**Proposed Erection of 1 number 4 Bedroom Dwelling & Double Garage
Land at The Entrance to Watersford Gardens, Horsemere Green Lane
Planning Reference CM/29/14/PL. Case Officer Mr. D Sullivan**

We write with reference to the proposed renewal of the planning application for the erection of one number additional four bedroom dwelling and double garage on land at the entrance to Waterford gardens reference CM/29/14/PL.

**Proposed Erection of 1 number 4 Bedroom Dwelling & Double Garage
Land at The Entrance to Watersford Gardens, Horsemere Green Lane
Planning Reference CM/10/08. Case Officer Mr. J Parsons**

Drawing Title:
Double Garage

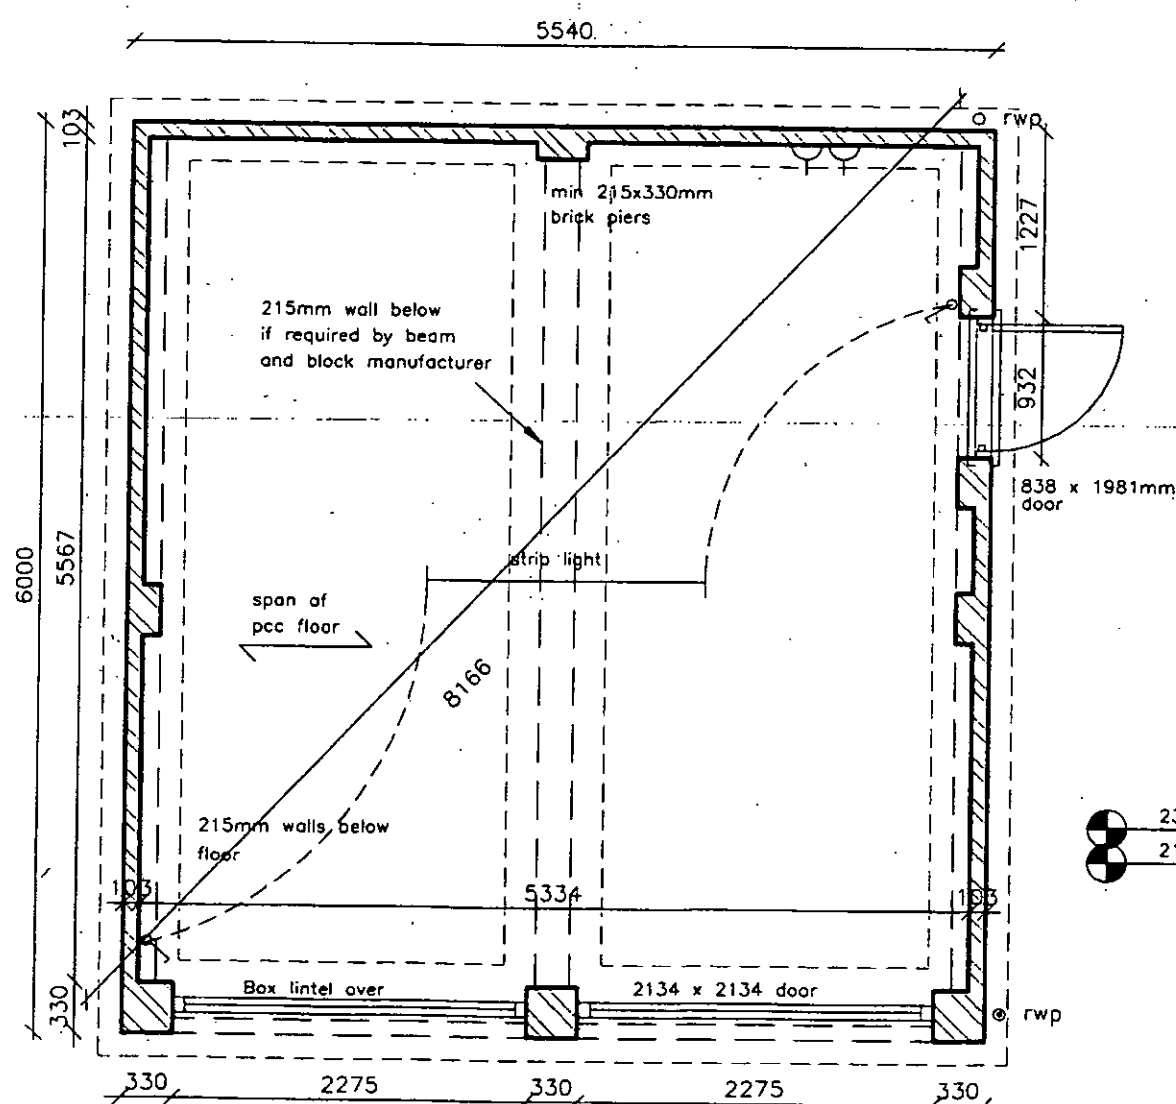
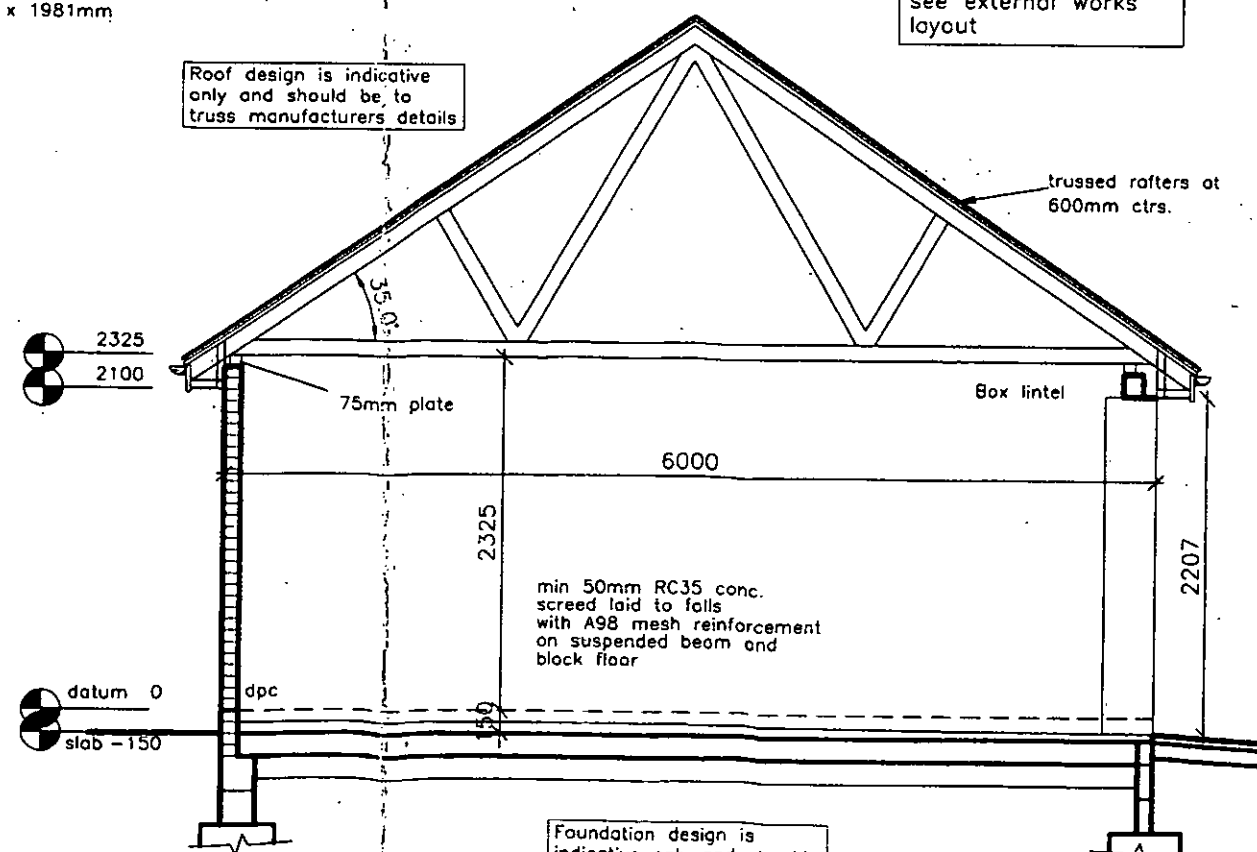
- 7) Domination of adjoining property at 29 Cropthorne Drive with the proposed garage height of 4.7m. This will be 2.9m above the height of the boundary fence.

- 8) Proximity of the proposed double garage to 29 Cropthorne Drive.
- 9) Proposed height of new dwelling at 9.65m – this will make the proposed dwelling very dominating.

Should planning approval be granted a party wall agreement will be required to build the proposed garage on the boundary with 29 Cropthorne Drive.

Drawing Title:
Design Proposal Block Plan

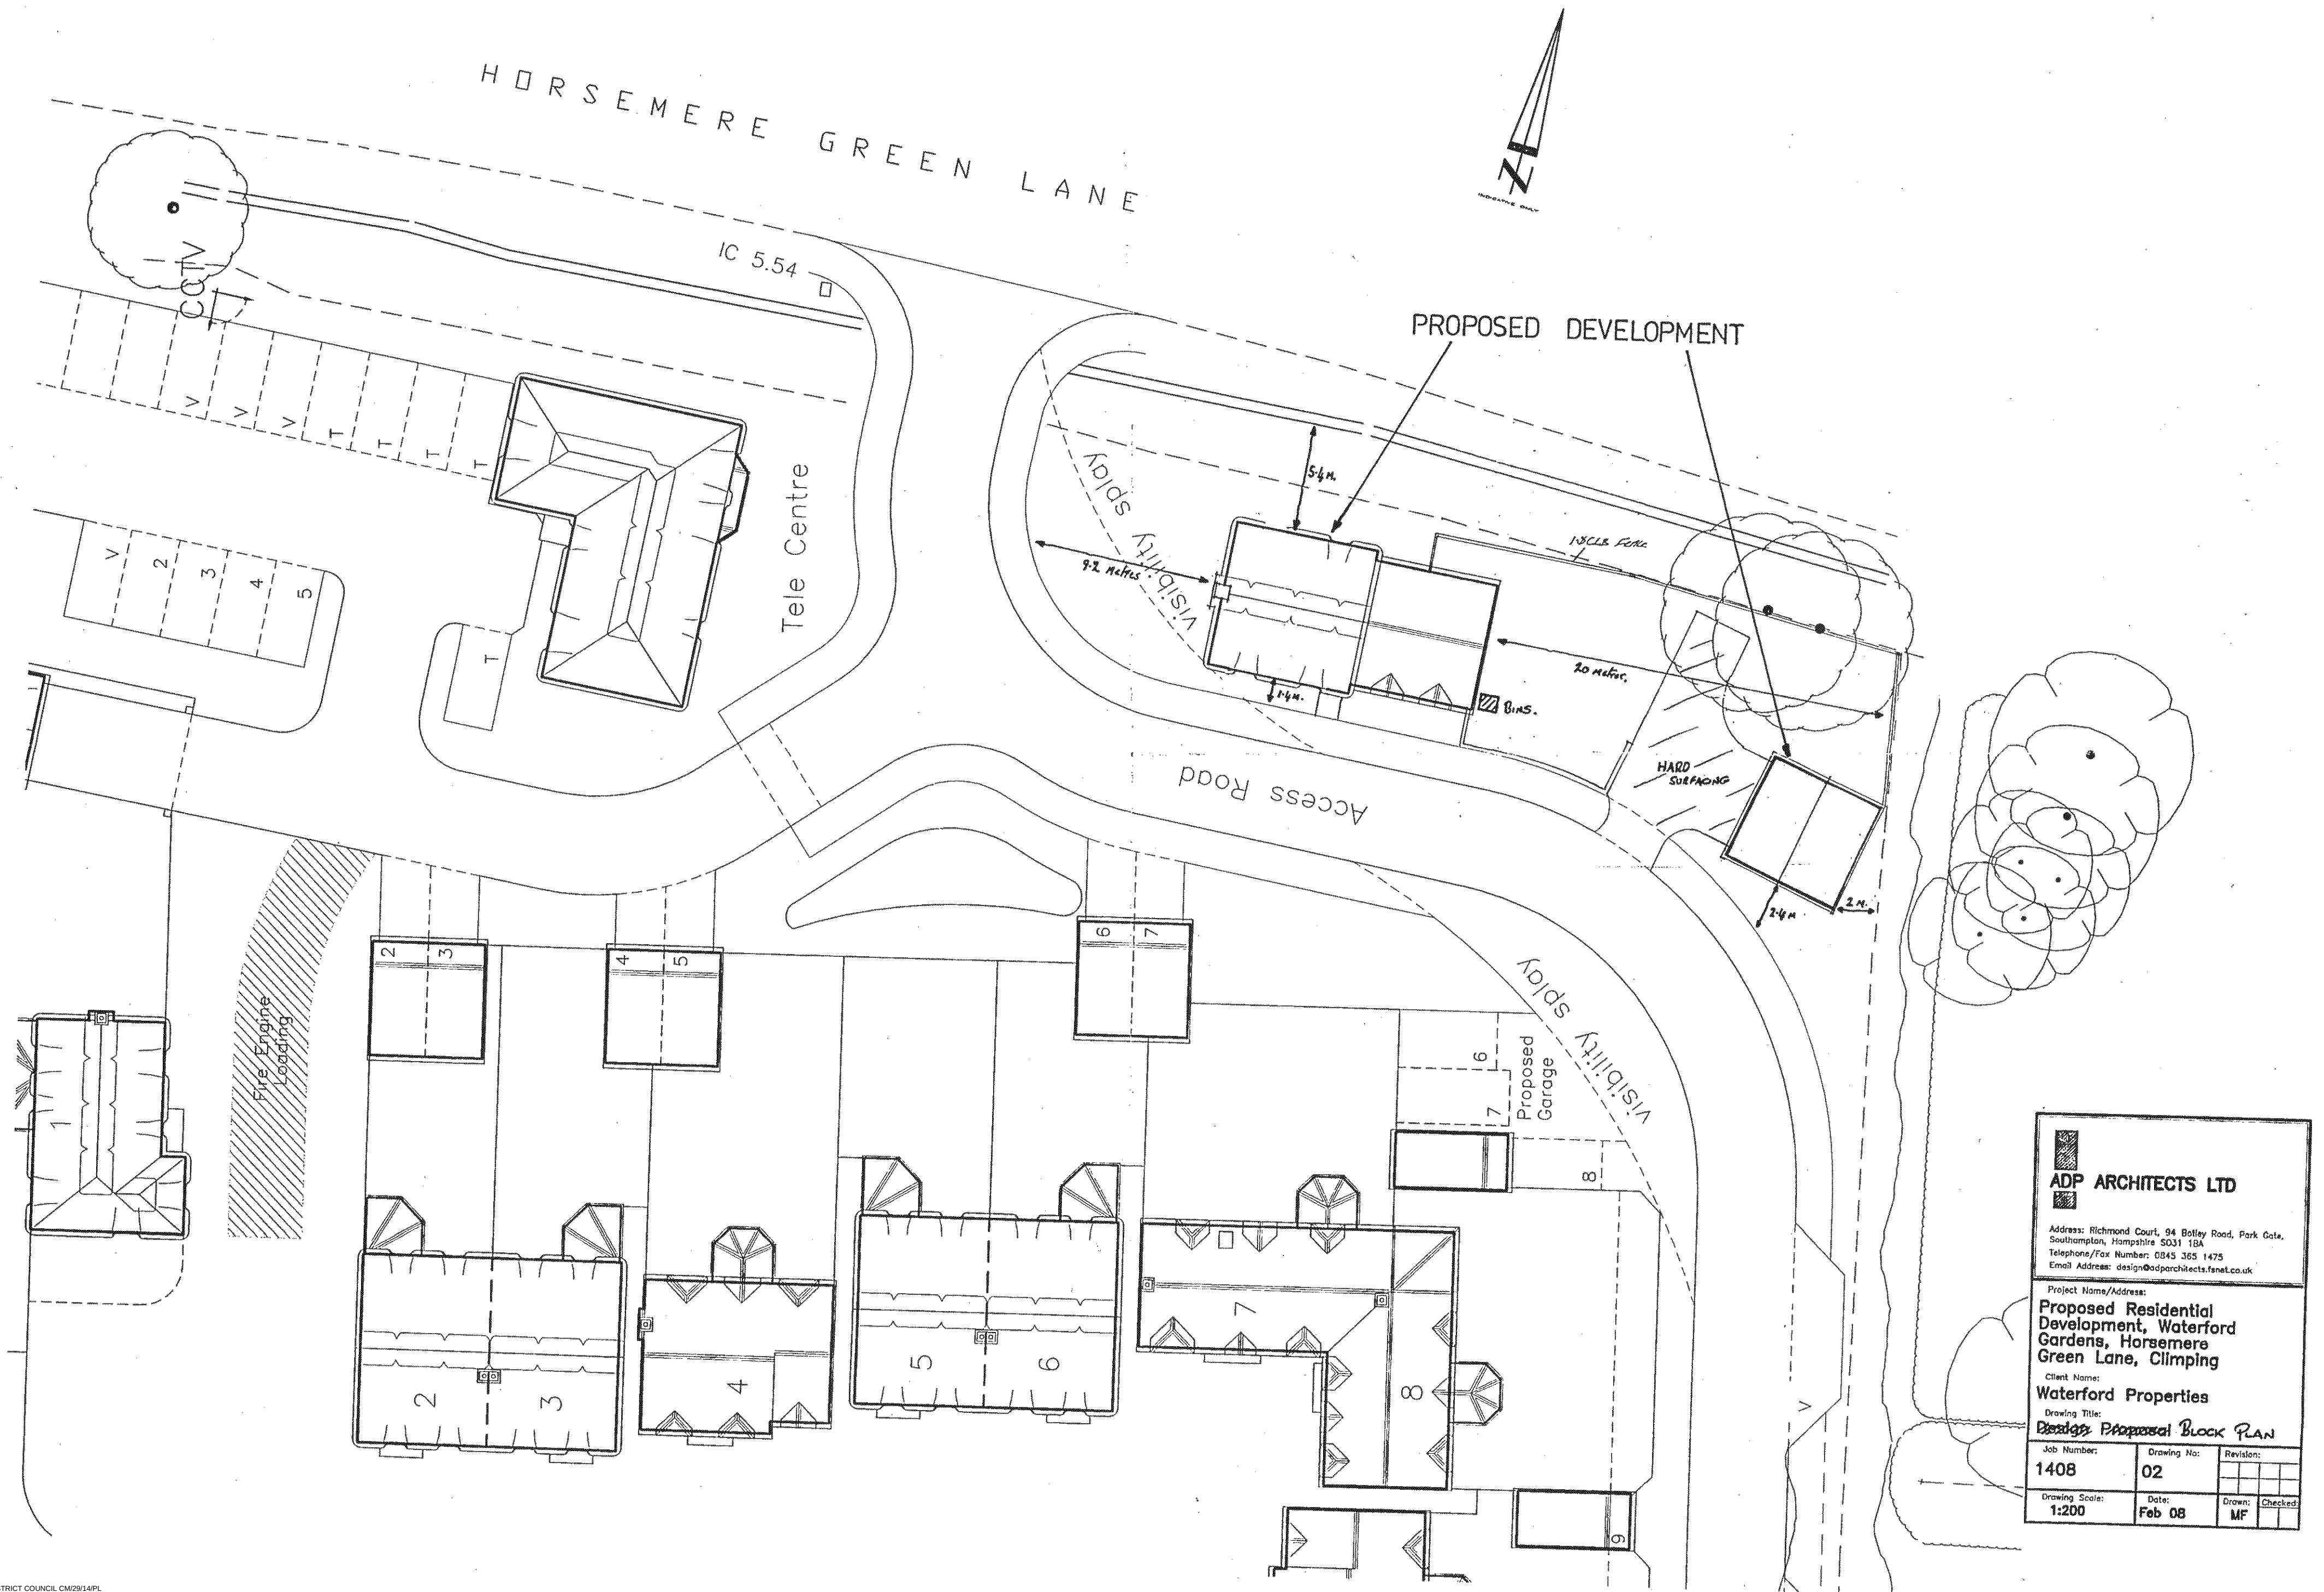
- 5) Trees shown on the planning application (ADP Architects Ltd drawing 1408/02) to the east of the proposed development do not exist and the applicant has no control of the adjoining land to be able to plant such trees. This is a false illustration and is highly misleading to the planning authority.

- 6) ADP Architects Ltd drawing 1408/02 does not show the location of 29 Cropthorne Drive and its proximity to the proposed dwelling and double garage - again this is highly misleading to the planning authority. We have sketched the approximate location of 29 Cropthorne Drive and attach a marked up copy of this drawing for your information.
